WEST SUSSEX COUNTY COUNCIL CONSULTATION

TO:	Arun District Council FAO: Simon Davis
FROM:	WSCC - Highways Authority
DATE:	1 September 2020
LOCATION:	The Former Ship Inn Aldwick Street Aldwick PO21 3AP
SUBJECT:	AW/197/20/PL Variation of conditions 8-concerning hours of deliveries & 10 types of vehicles making deliveries following AW/211/14/PL. This application is in CIL Zone 4 (Zero Rated) as 'other development'.
DATE OF SITE VISIT:	n/a
RECOMMENDATION:	No Objection
S106 CONTRIBUTION TOTAL:	n/a / £ See below for breakdown.

Articulated Deliveries Vehicle
with Refuse Vehciles Passing
scale 1:500 @ A1

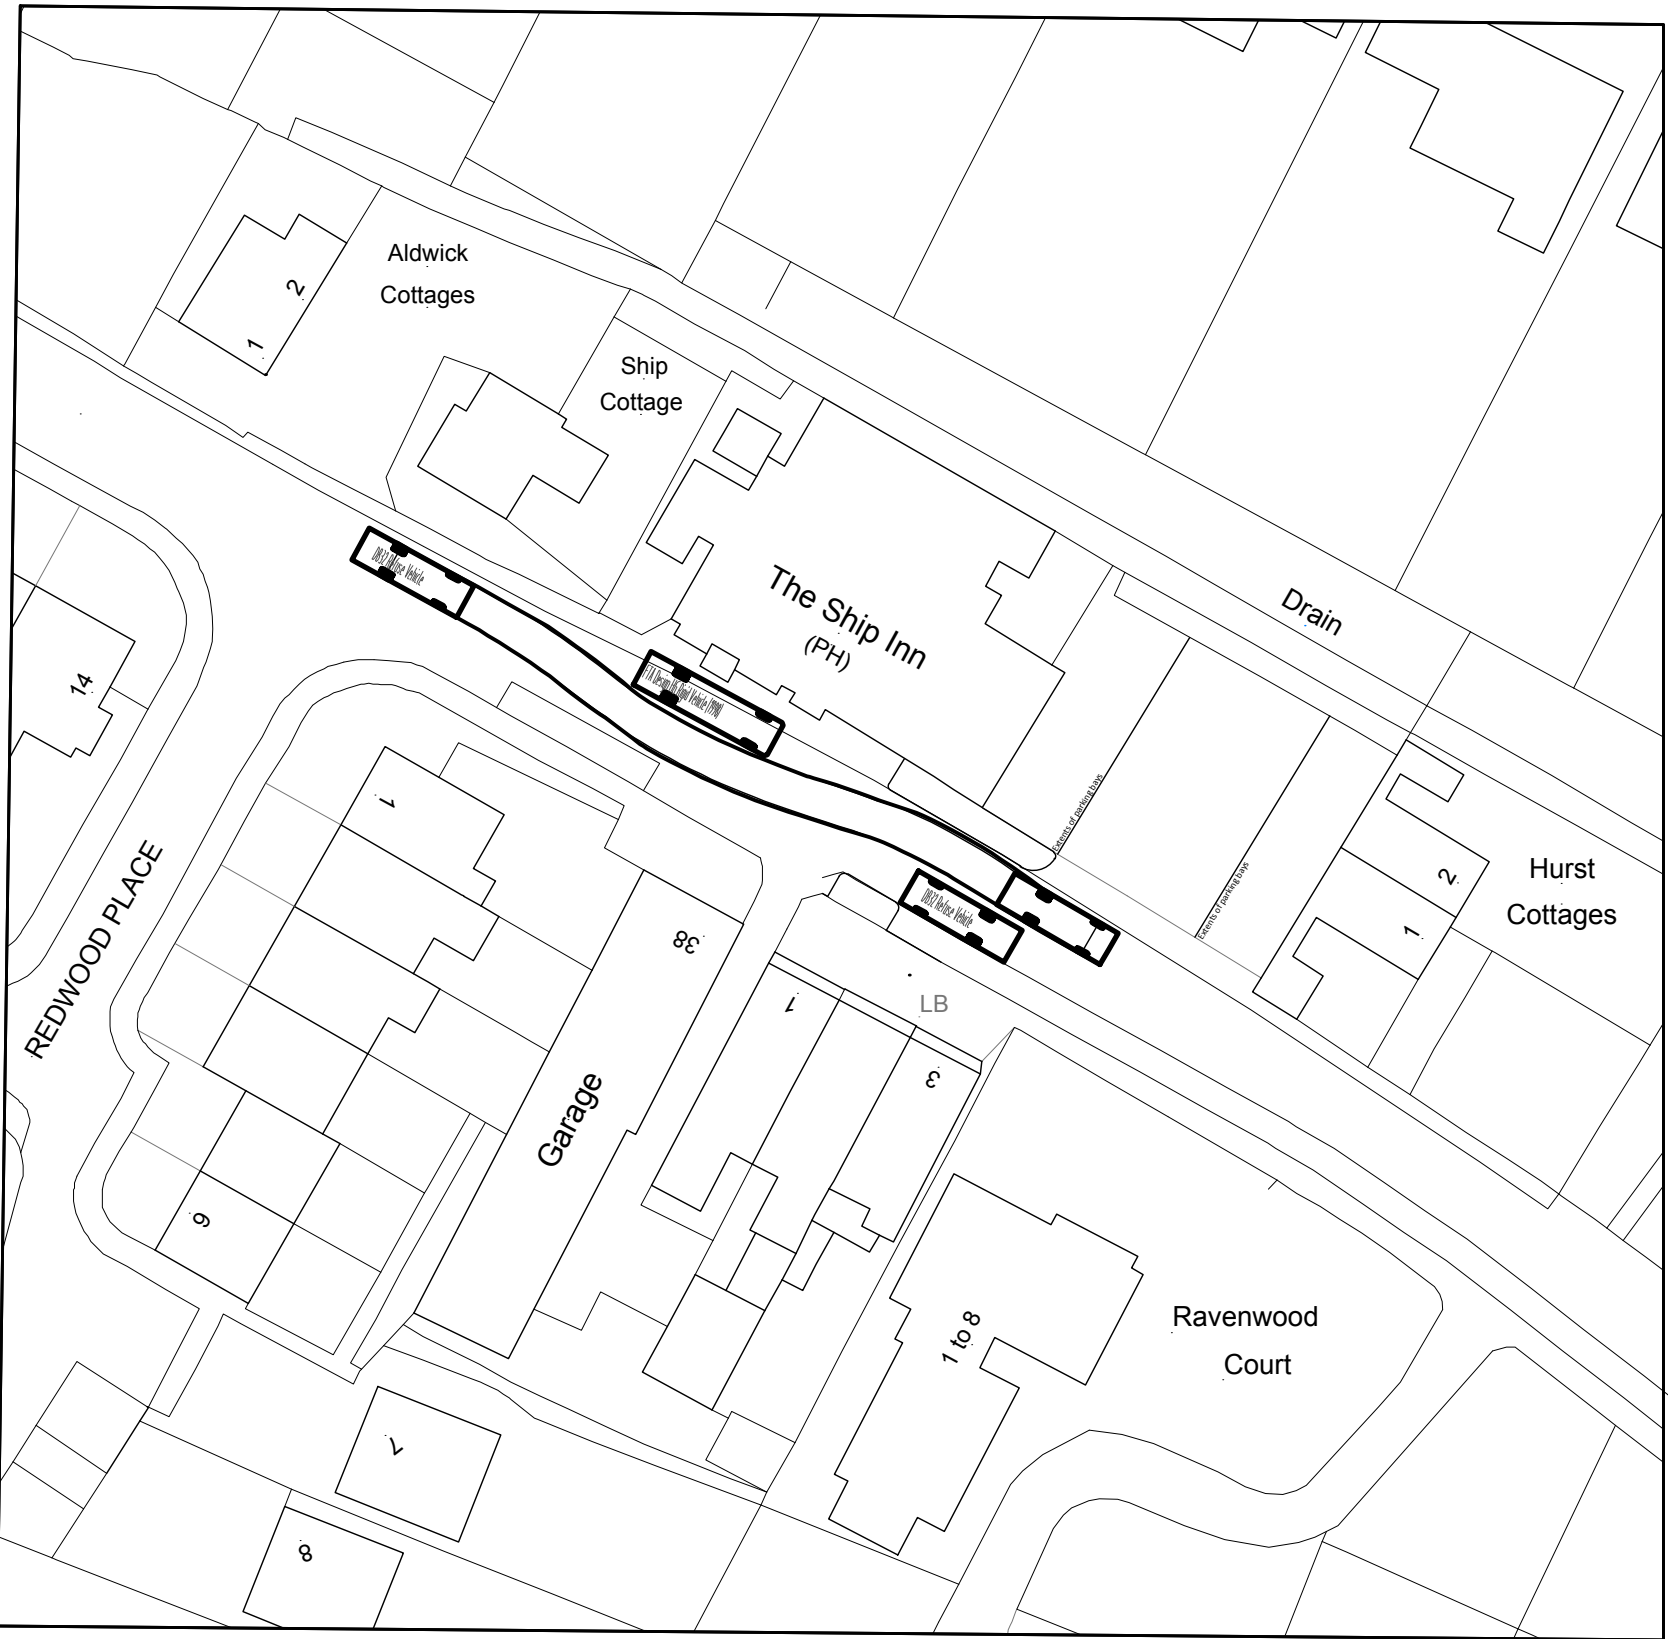
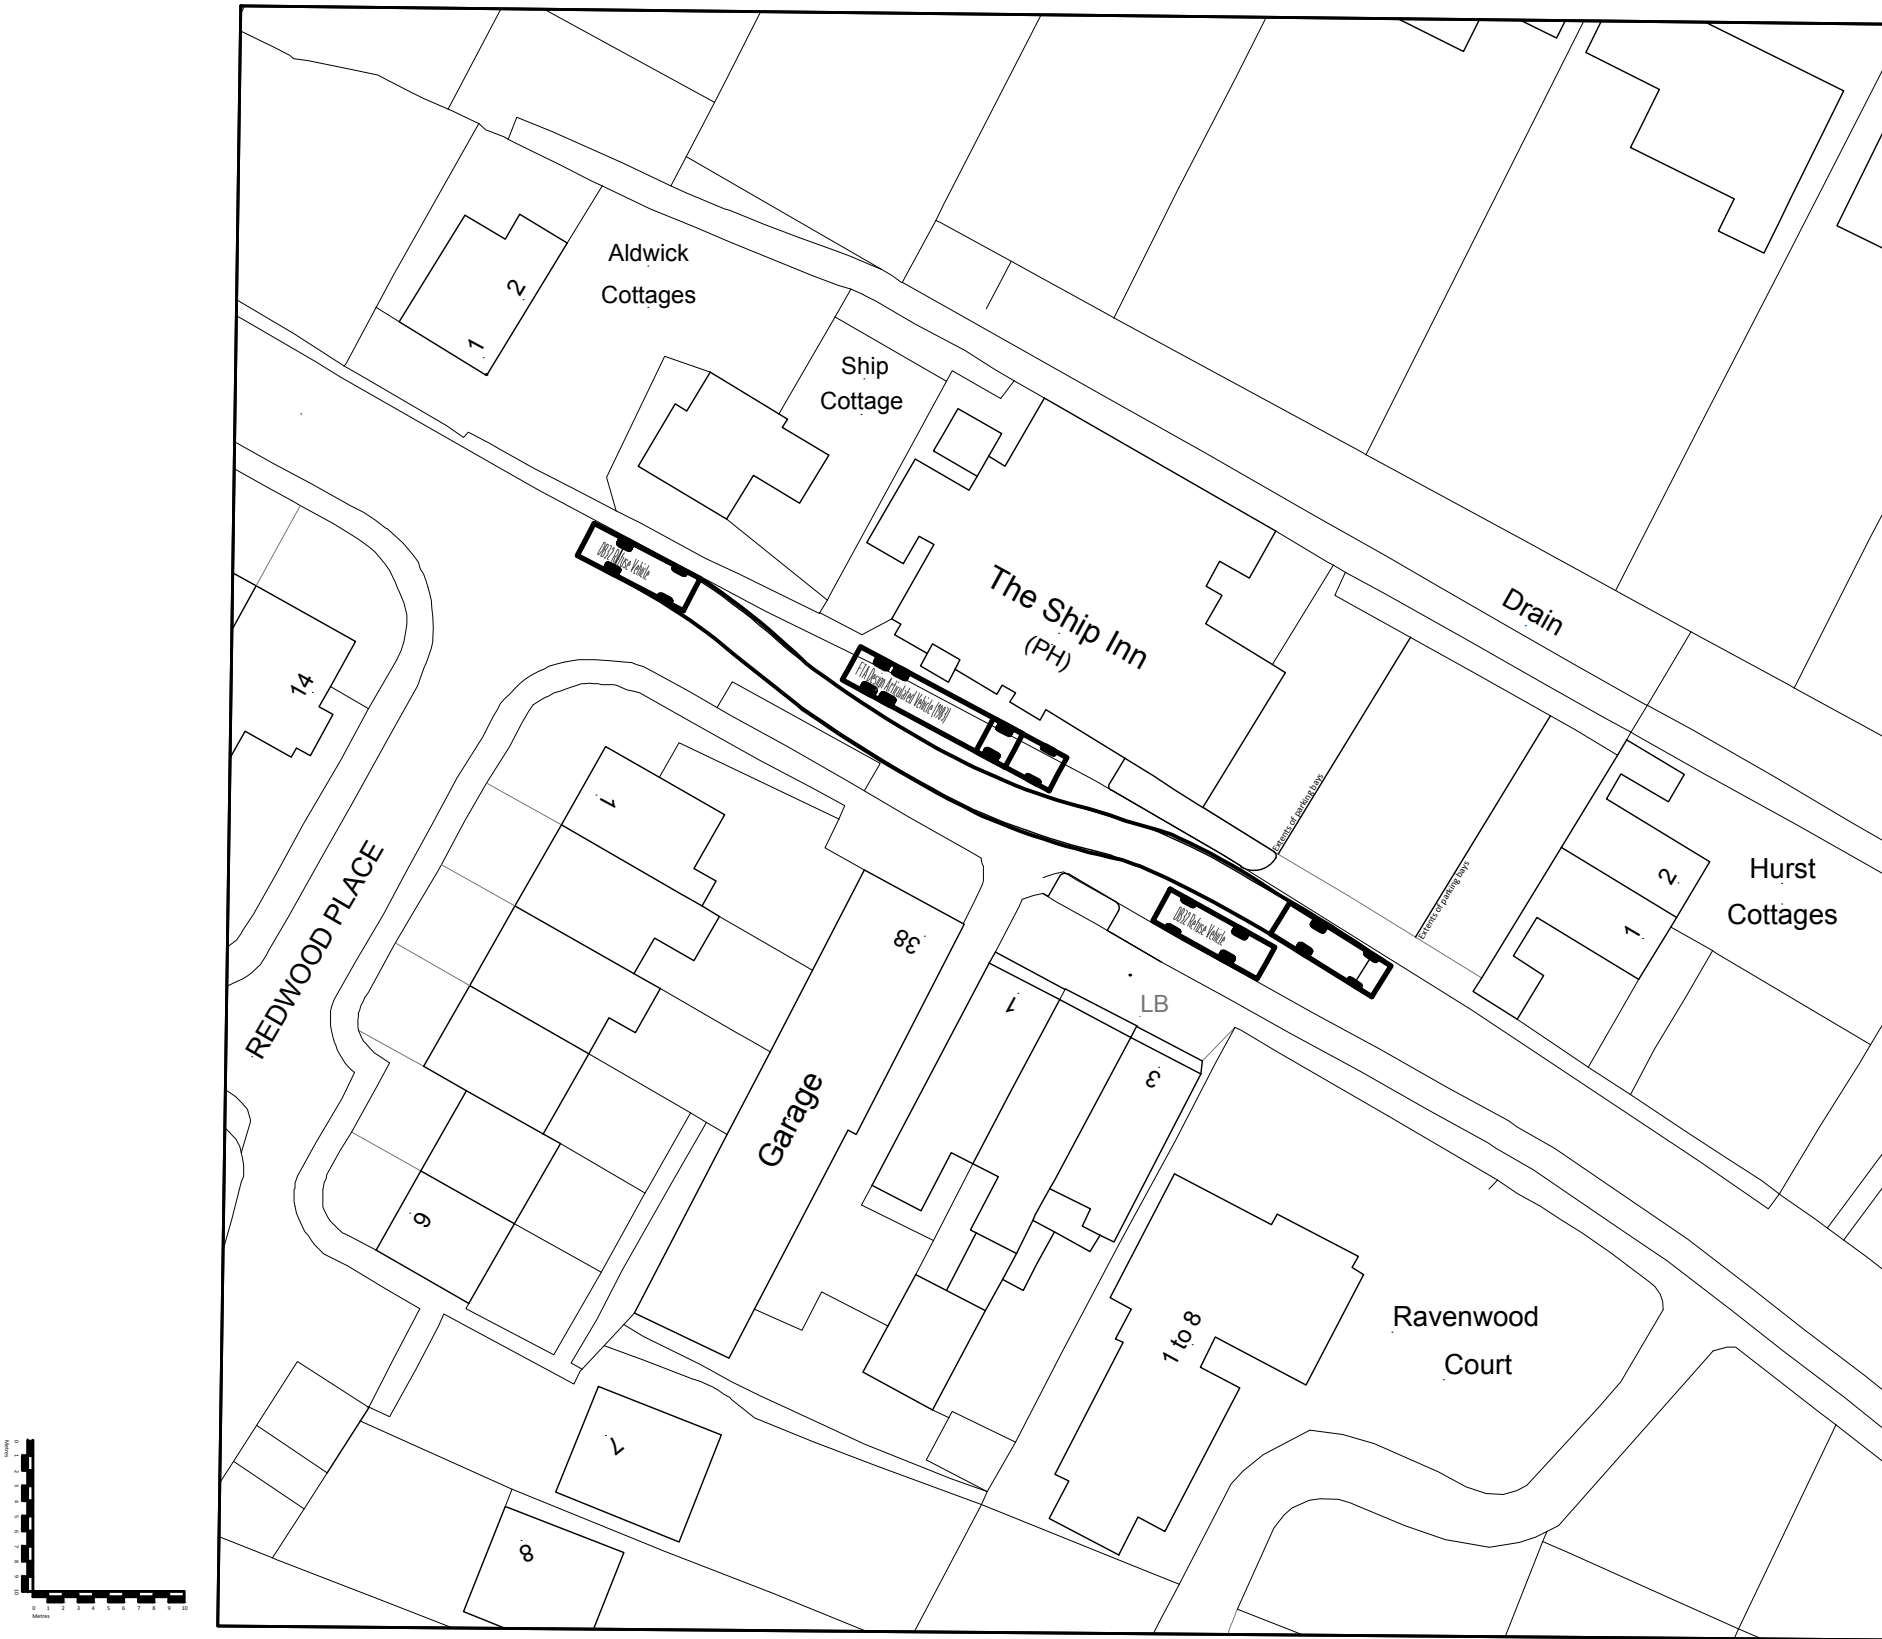
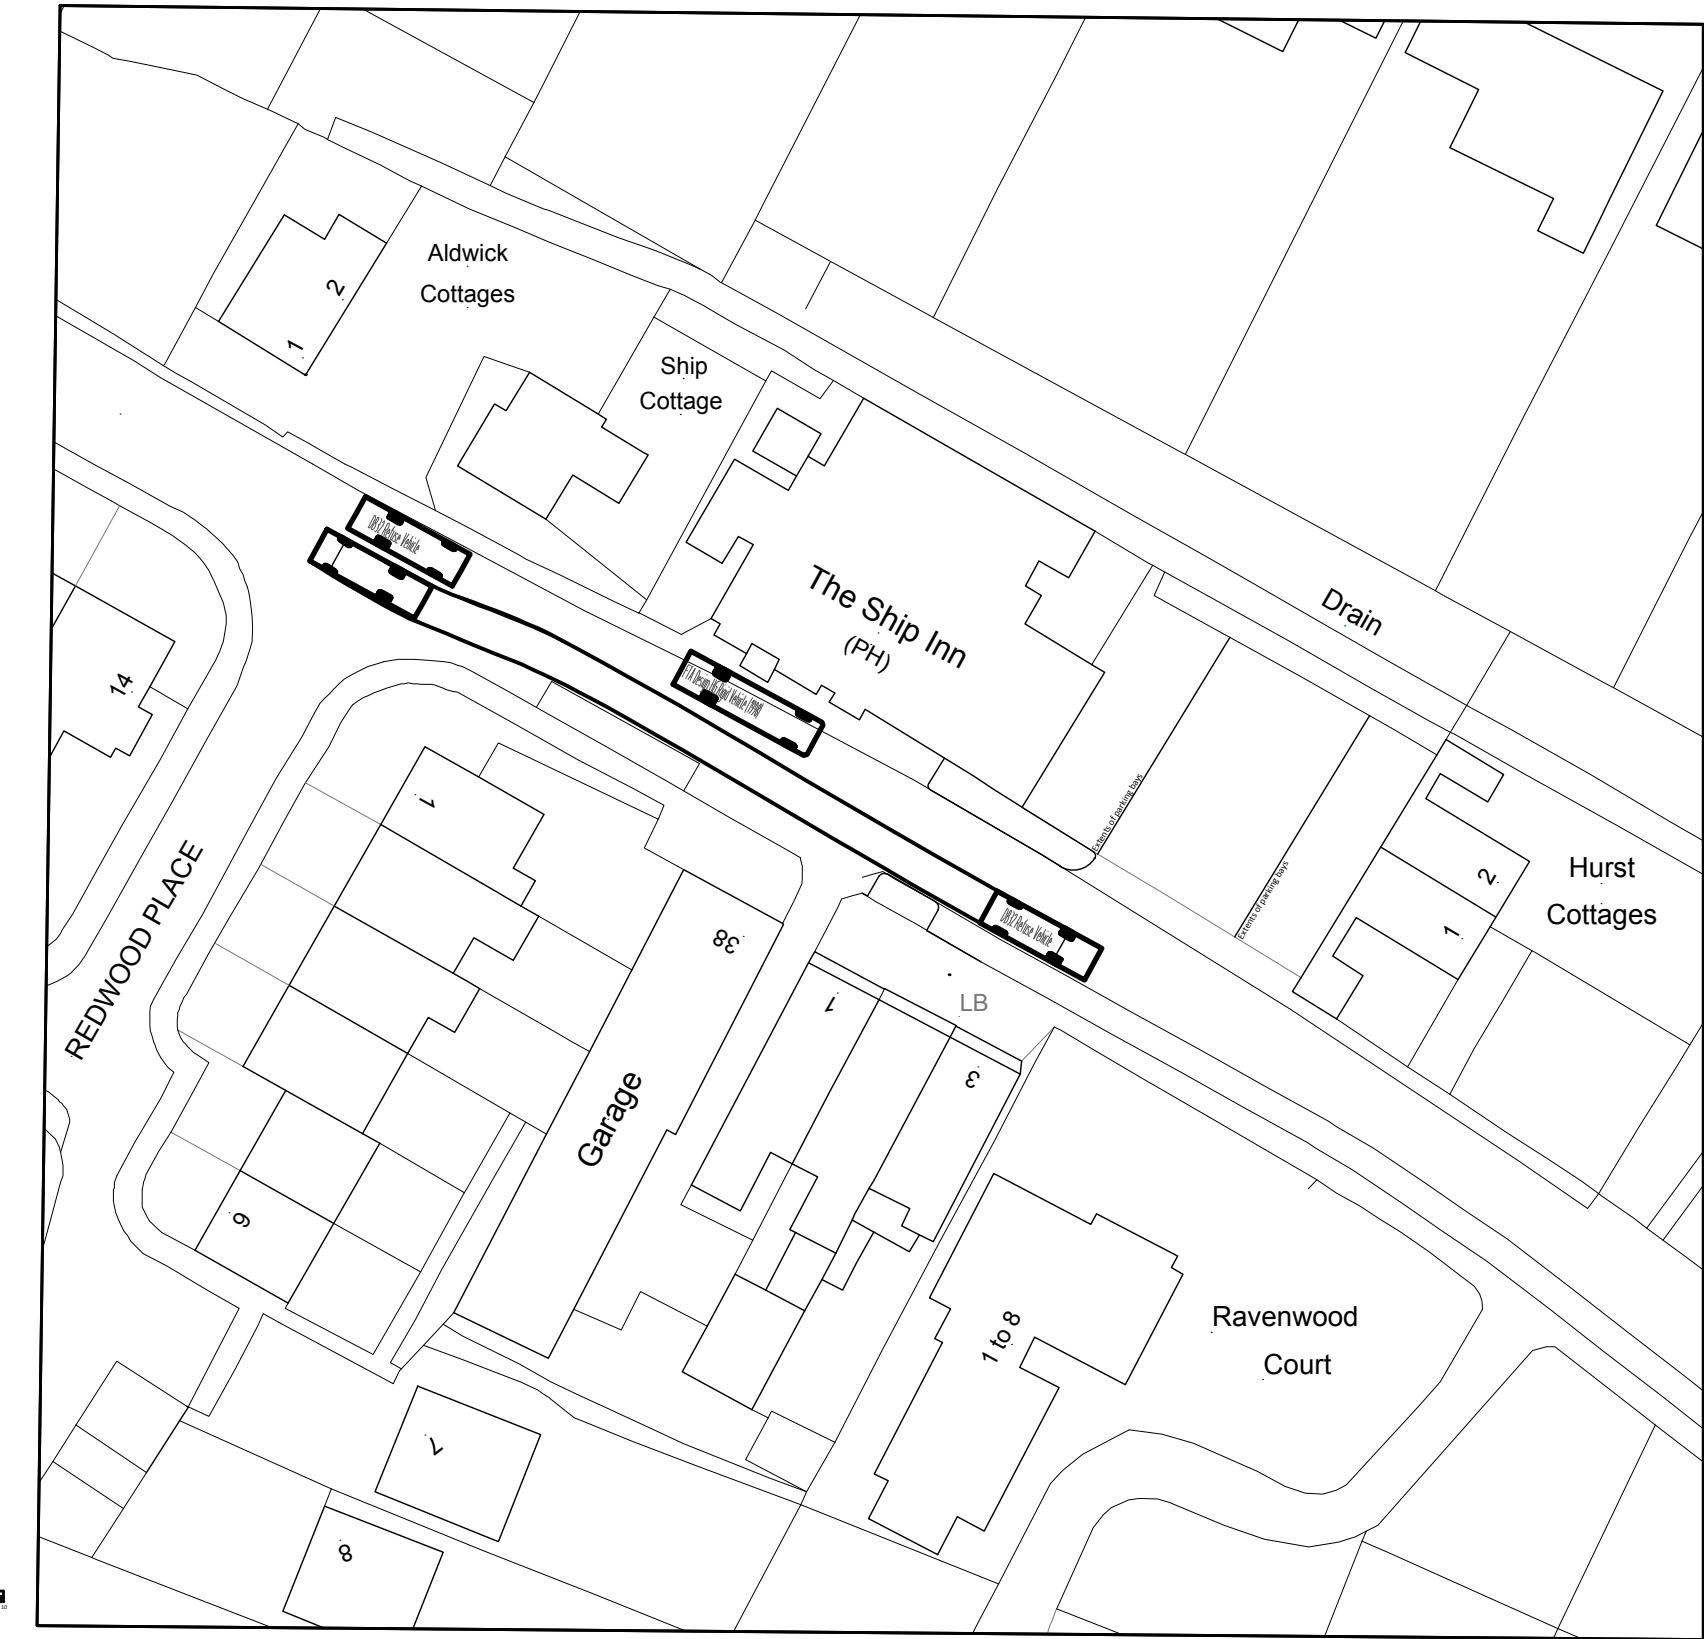
Swept path diagrams show a combination of movements and vehicle types to demonstrate a rigid vehicle, or articulated vehicle can load and unload in the highway without causing any significant harm to the operation of the highway network.

It is noted the largest vehicle used in the delivery management plan would be an articulated vehicle with dimensions of 2.6m in width and up to 16m in length. It has been said this will only be used on rare occasions and given the street dimensions would still allow a car or refuse truck to pass freely. Based on the submitted highway plan which shows the dimension of the road at three points, it is
